Current Zoning: N1-B (Neighborhood 1-B)
Proposed Zoning: N2-B(CD) (Neighborhood 2-B, Conditional)

Approximately 6.42 acres located on the north side of Tom Hunter Road, west of Hunter Oaks Lane, and east of Hidden Stream Court.

The petition proposes to redevelop property near the Hidden Valley neighborhood currently occupied by three single family dwellings with an affordable multifamily residential community.

ⓘ SITE - 06/19/2025

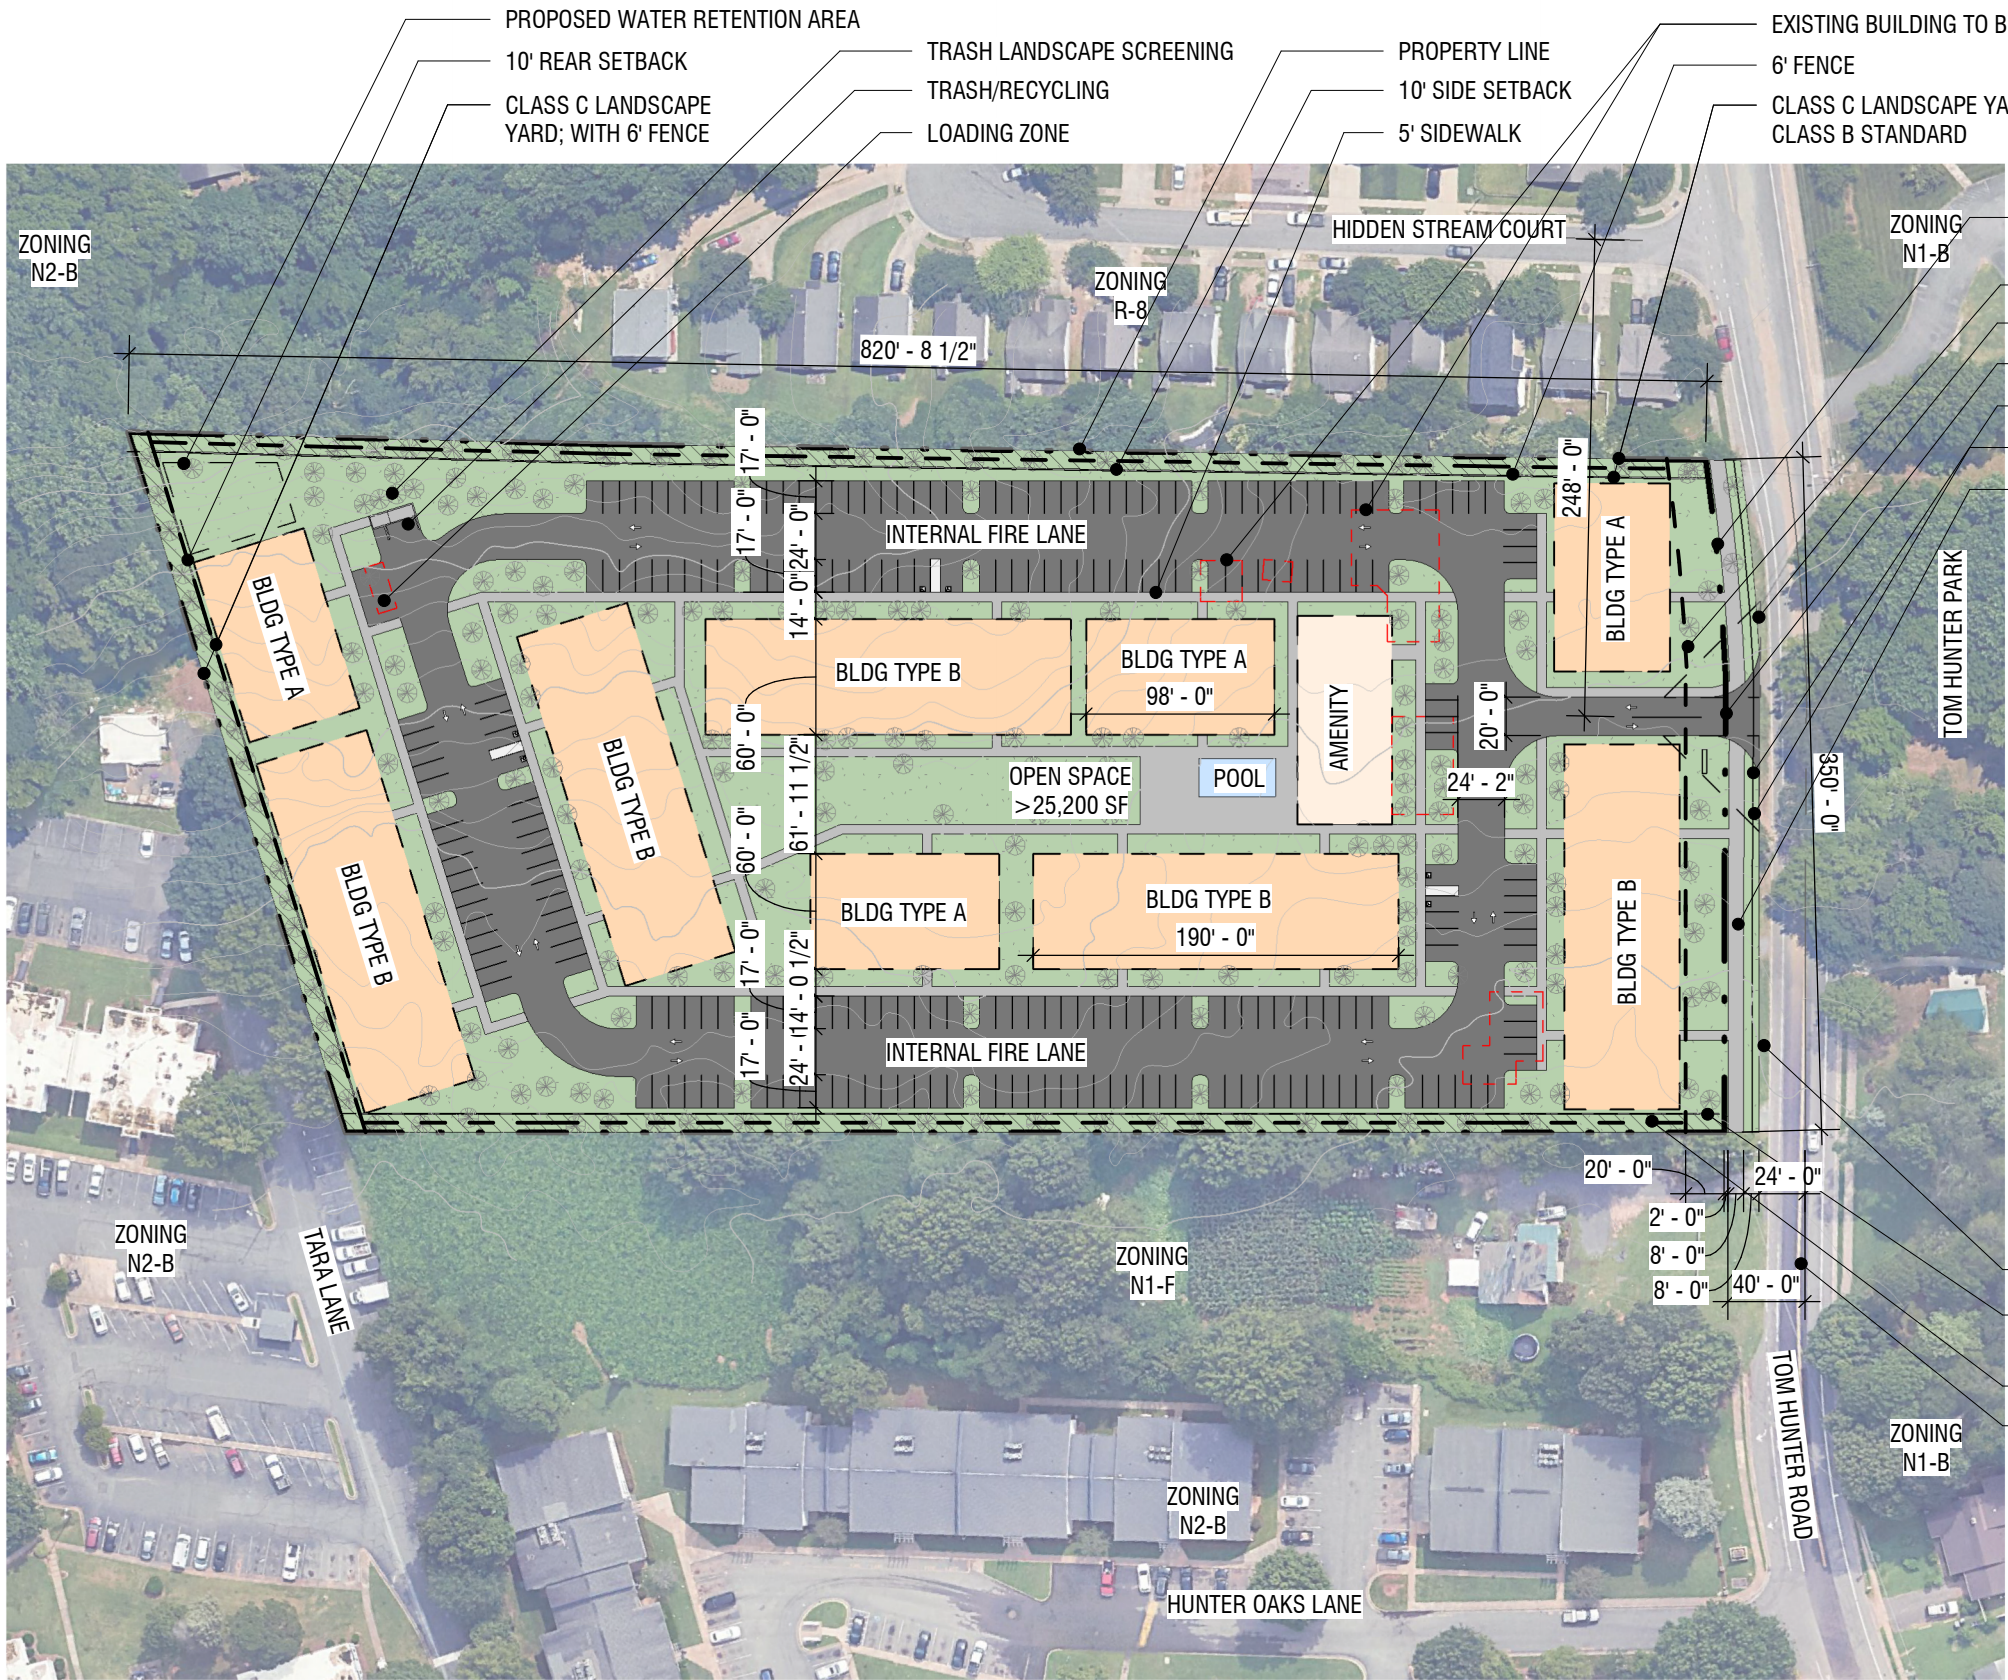
1. Remove open space note "Provide more detail for the central open space by including the language below in the open space standards."
 2. Revise open space note A to quantify proposed enhanced plantings.
 3. Remove the number of parking spaces from the development data table. If not removed, you will be held to that specific number in permitting regardless of the number multifamily units constructed.
 4. Revise streetscape conditional note to reference 8' sidewalk as opposed to 8' multi-use path.
-
